HERTFORDSHIRE ECOLOGY

Application: Expansion and adaptation of existing car park, including construction of new single suspended level parking deck, reorganisation of road and pavement arrangement, introduction of additional cycle parking, junction improvements and associated landscaping improvements

Address: Campus West The Campus Welwyn Garden City AL8 6BX

Reference 6/2021/2207/MAJ

### 1.1.3 Result overview, Spill lighting north

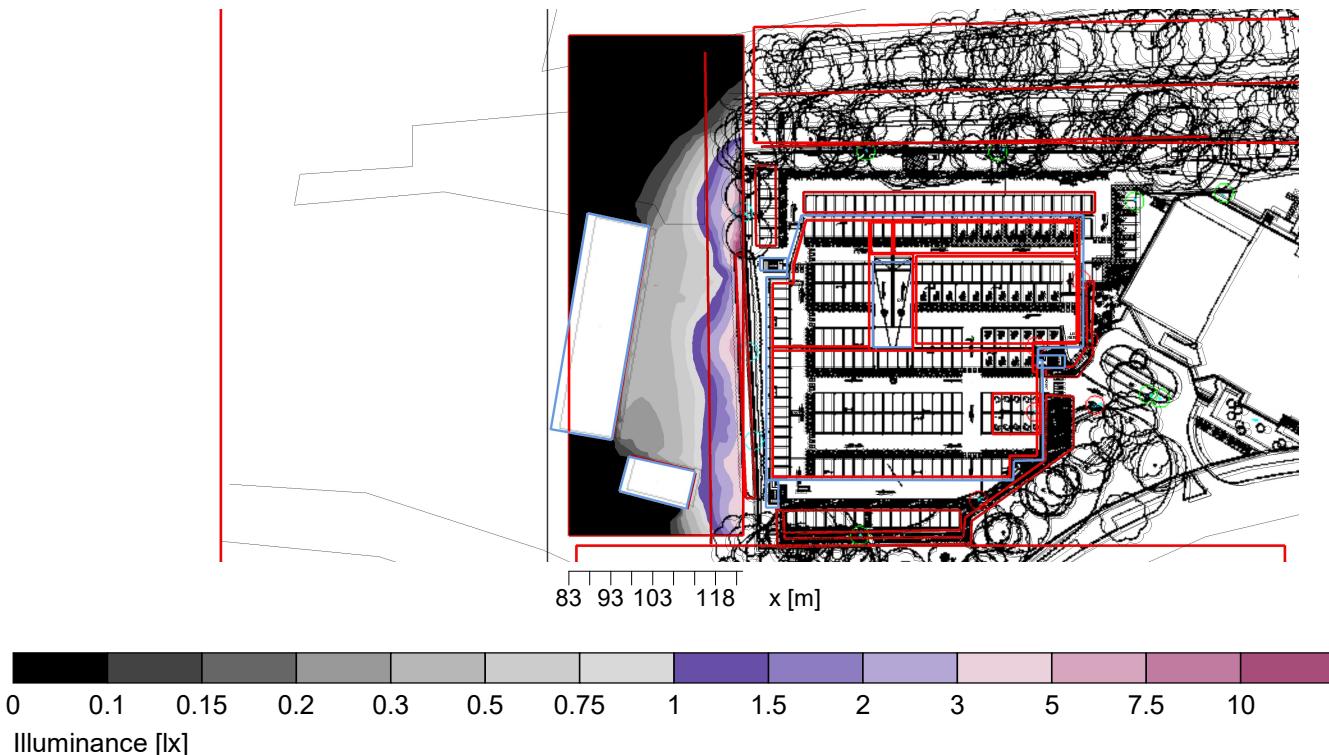
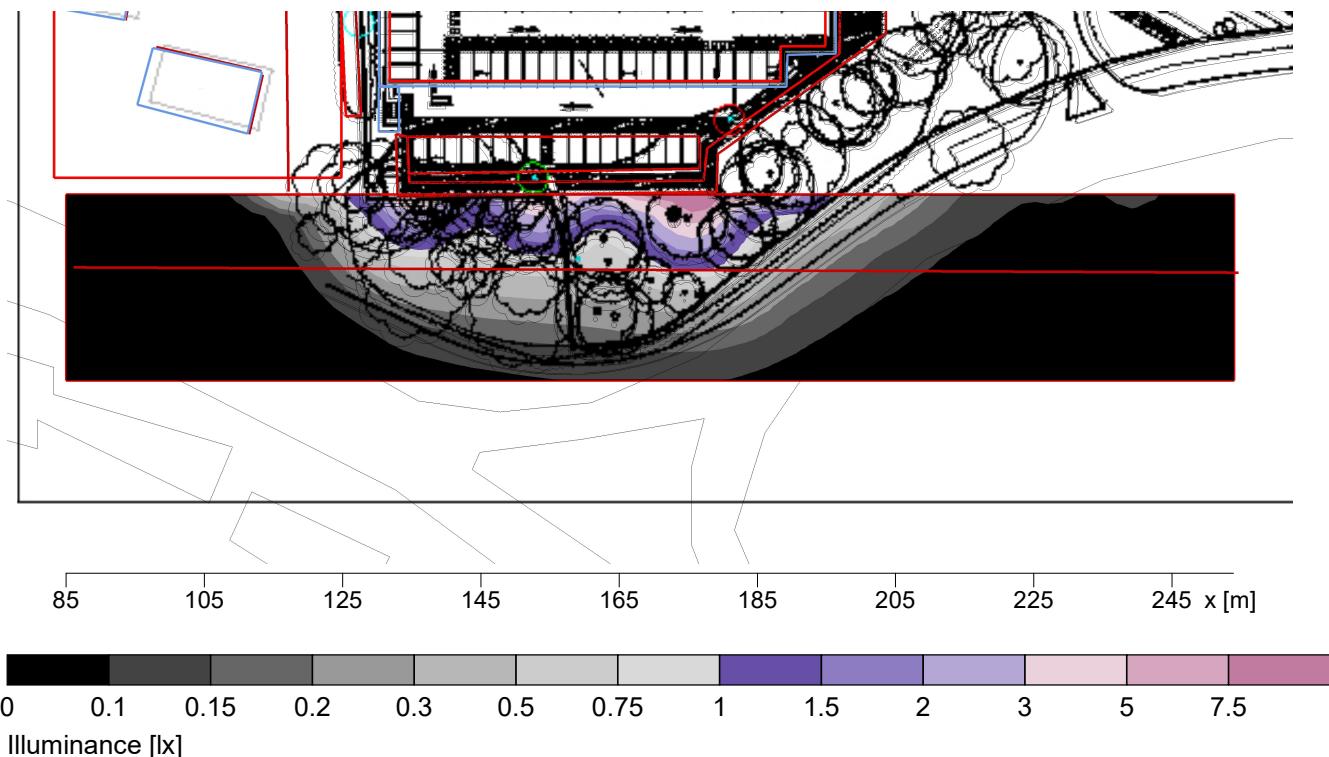
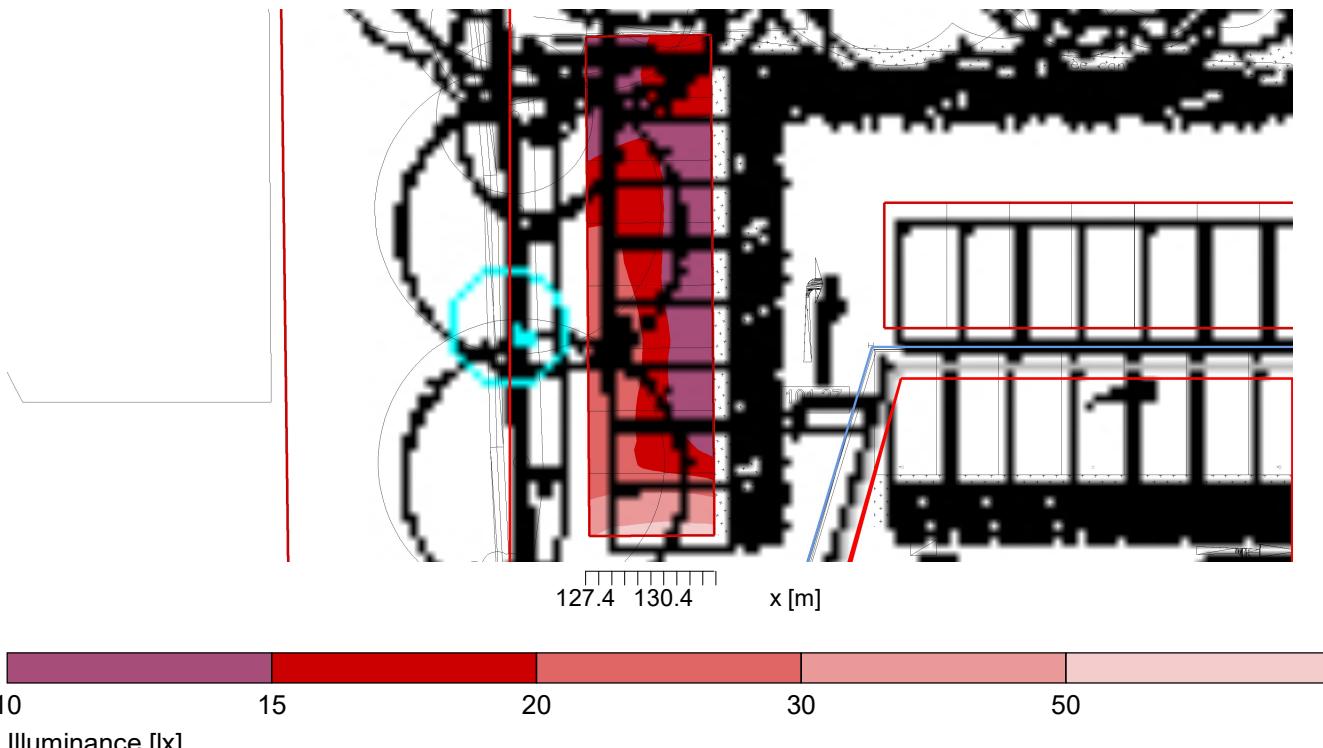
lighting should avoid illuminating the neighbouring Local Wildlife Site and boundary vegetation to prevent it affecting the natural behaviour of nocturnal animals such as bats. The lighting plan included in the application does not include the location of these areas of vegetation and so does not allow the LPA to adequately assess any likely impact. I advise this is updated to include the location of the Local Wildlife Site and boundary vegetation. This needs to be sufficient to assess the biodiversity impact in terms of light spill, glare and colour temperature.
